Ribble Valley Borough Council
Council Offices
Church Walk,
Clitheroe
Lancashire
BB7 2RA

Phone: 0300 123 6780
Email: developeras@lancashire.gov.uk
Your ref: 3/2025/0935
Our ref: 3/2025/0935/HDC/KW
Date: 18 December 2025

Location: Lower Moss Farm Lower Lane Longridge PR3 2YH
Proposal: Regularisation for the proposed development of 3No. holiday cottages following planning permission being granted for 10No. holiday cottages (application reference 3/2017/0357).
Grid Ref: 361065 436542

Project No: RAI/12 Dwg 02

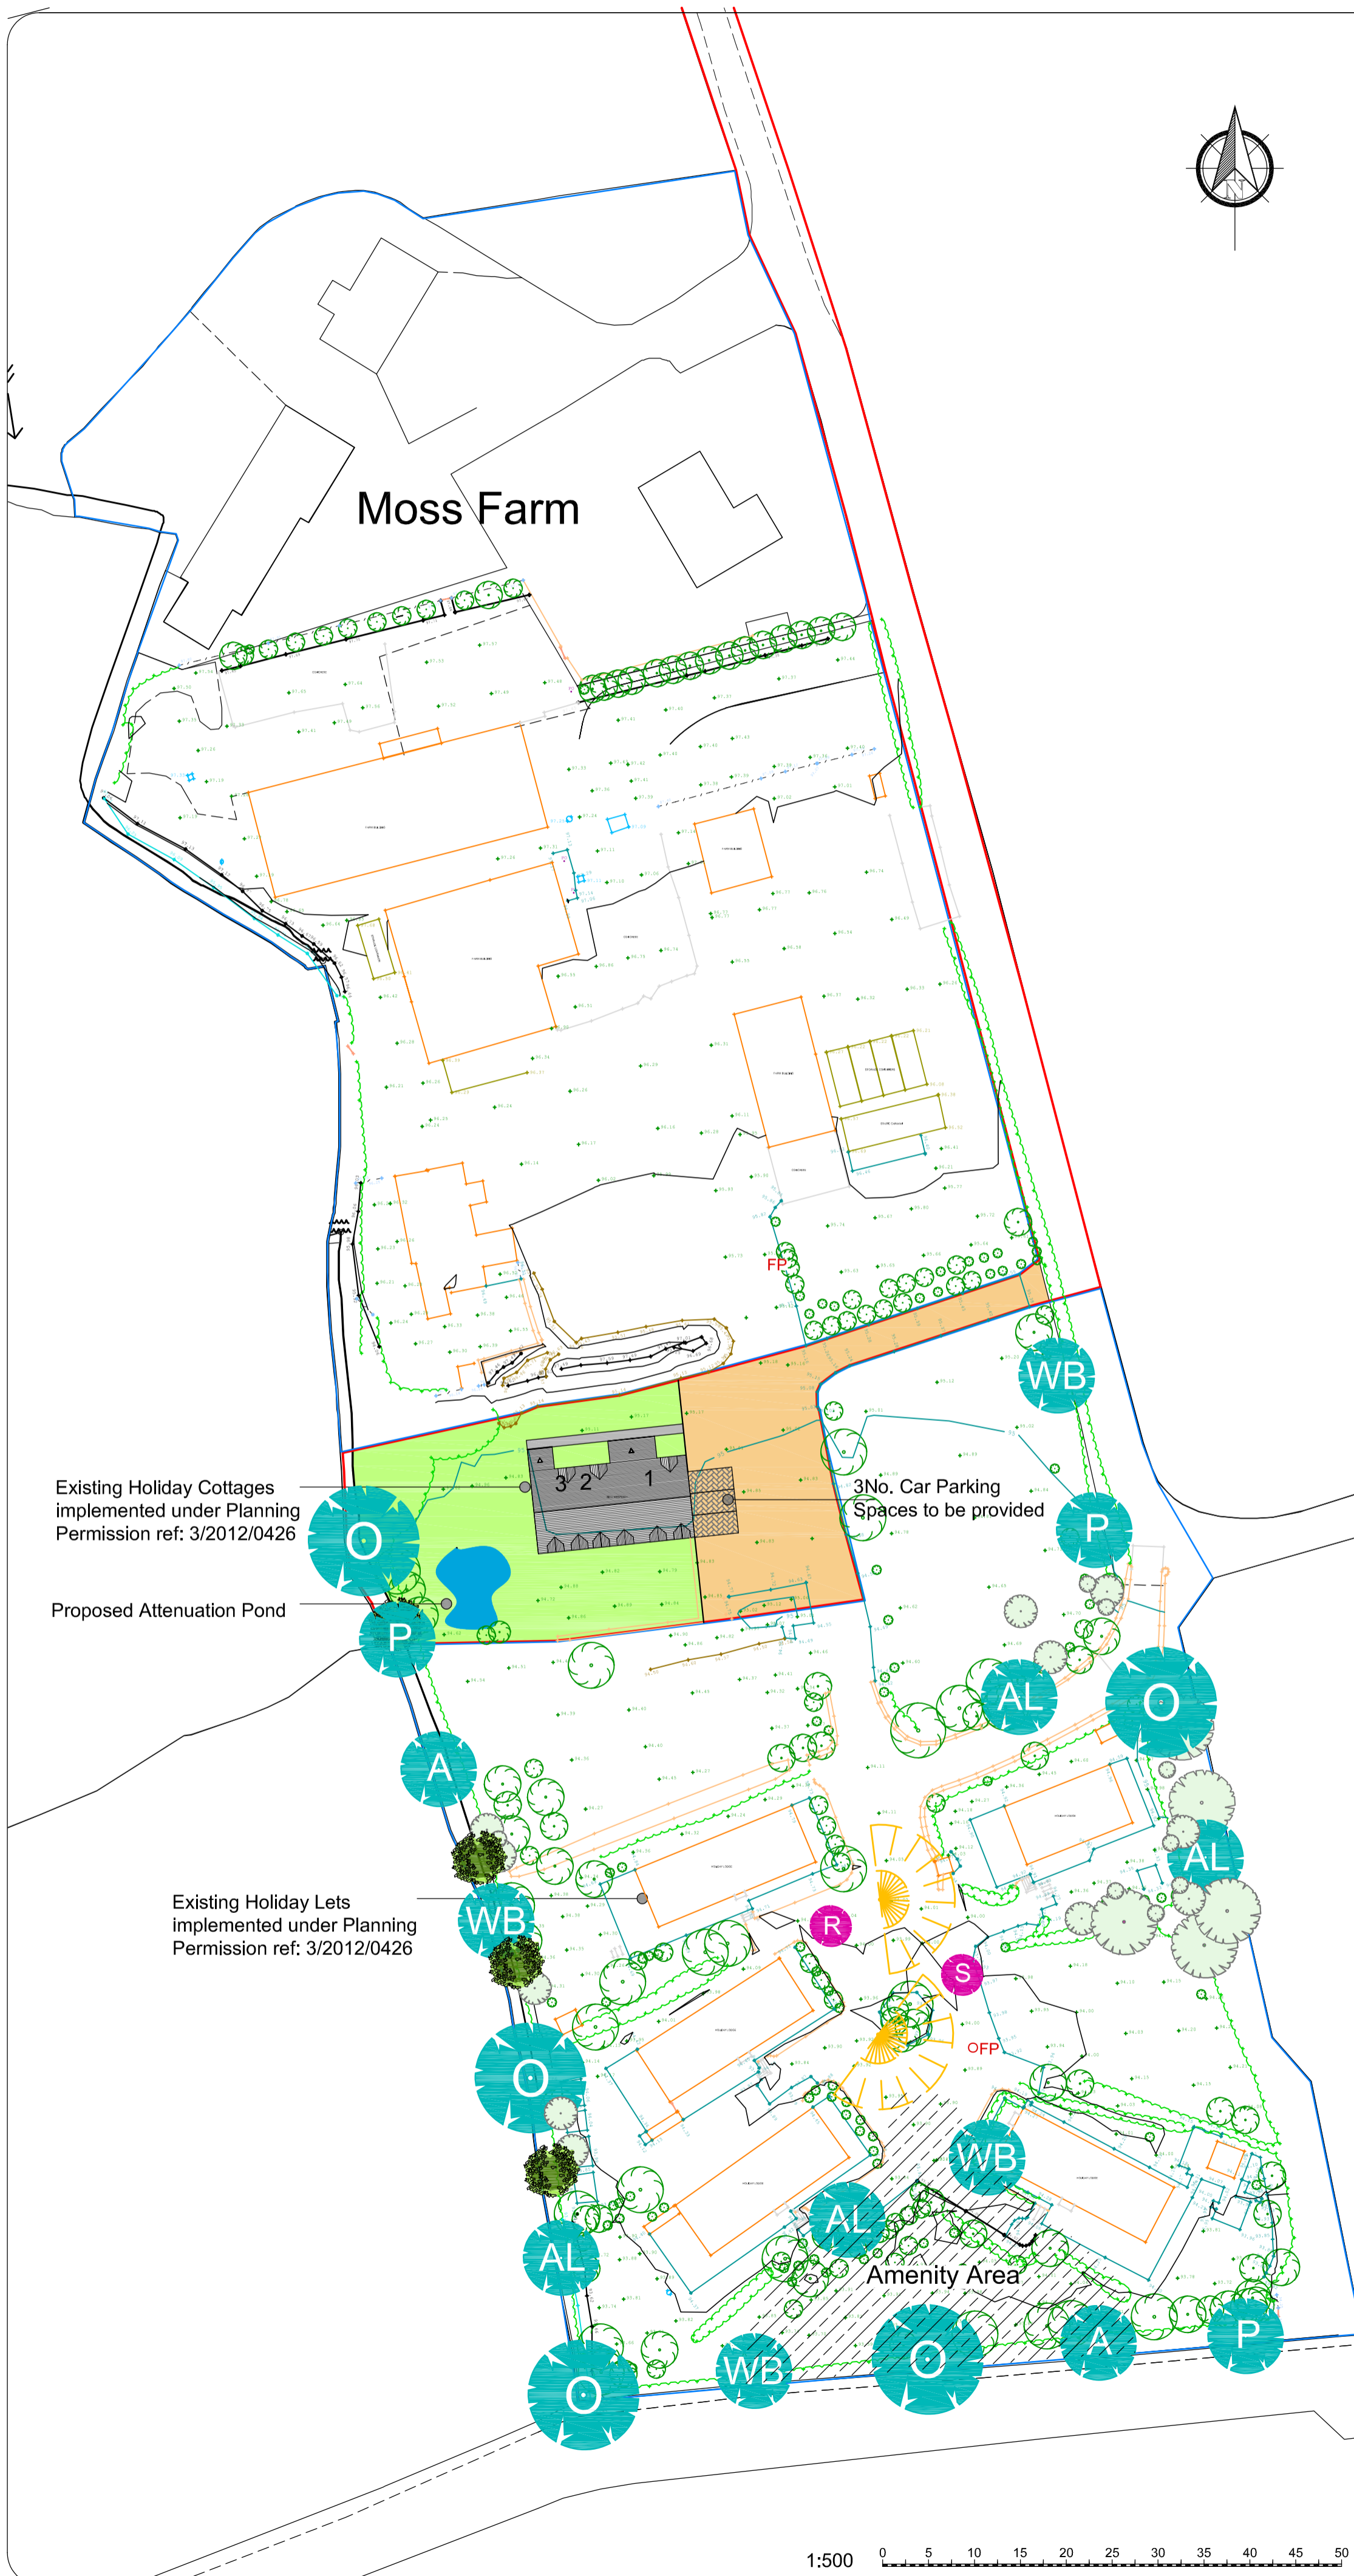
The LHA have reviewed drawing number 02 titled Proposed Site Plan and are aware that 3 off street parking spaces have been highlighted within the plan. Given that the holiday lets are two beds the LHA would look for 2 off street parking spaces to be provided per holiday let. As such, the LHA requests that 6 off-street parking spaces be provided. When considering the size of the gravel driveway shown within the plan, the LHA are of the opinion that 6 off-street parking spaces, alongside acceptable manoeuvring space, can be achieved.

1. The development hereby permitted shall not be occupied or brought into use until car parking and turning areas for six vehicles have been provided in full and are available for use. The car parking and turning areas shall thereafter be kept available for the parking and manoeuvring of vehicles at all times.
